**Subject: Woodlawn Mine Modification 3 (MP07_0143-Mod3)
Comments in relation to Modification 3 Report**

Council has reviewed the Modification Report prepared by Onward in relation to Modification 3 for Woodlawn Mine and provides the following comments.

Figure 5-1 Revegetation areas as per the consent

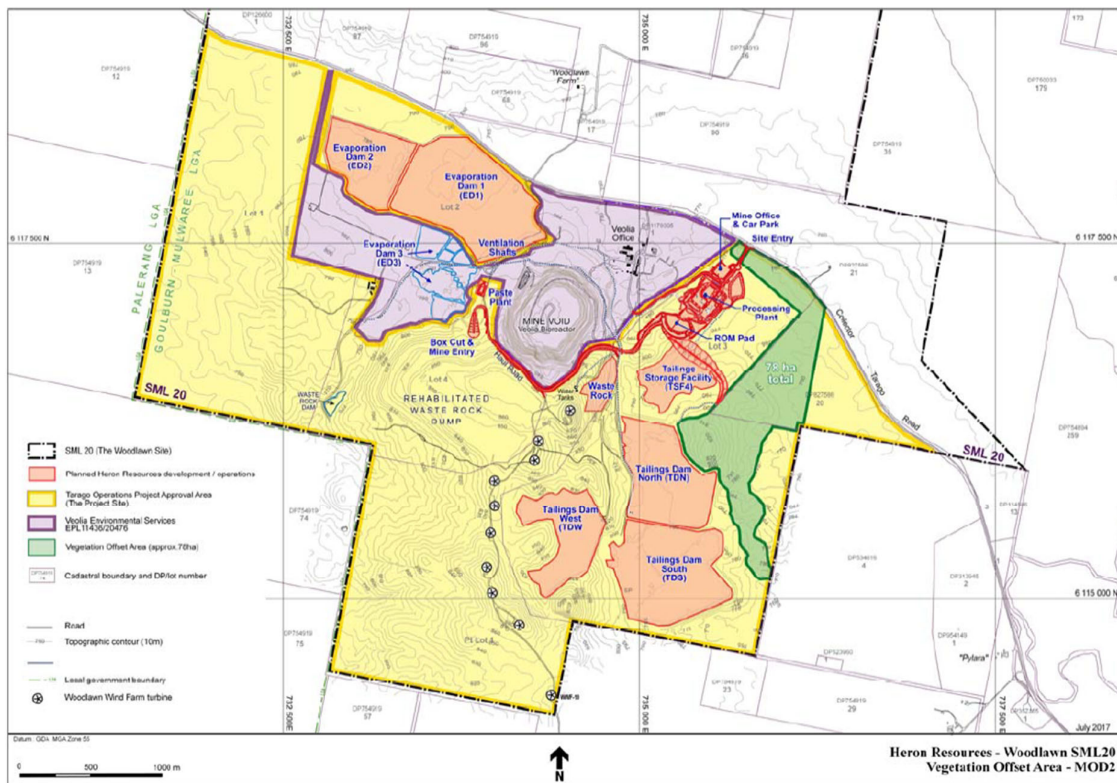
In relation to Section 3.5, the proposal to change the reference from a *revegetation area* to a *vegetation enhancement area* is noted. However, it is unclear given the previous section in relation to removal of a reference to revegetation with plant species characteristic of the Western Tablelands Dry Forest vegetation community that this is still referenced in the below changes as an objective. The provision below shows that this plant community is proposed to be limited to the designated revegetation area only.

Council would not support this element of the modification as currently proposed without having a better understanding of what is proposed for the revegetation, noting the confusion between tables 3.3 and 3.4 in relation to what is proposed to be planted in this specific area as opposed to the site as a whole. Also, there is no explanation in relation to how enhancement would be measured, therefore further information is required to be provided to justify this change.
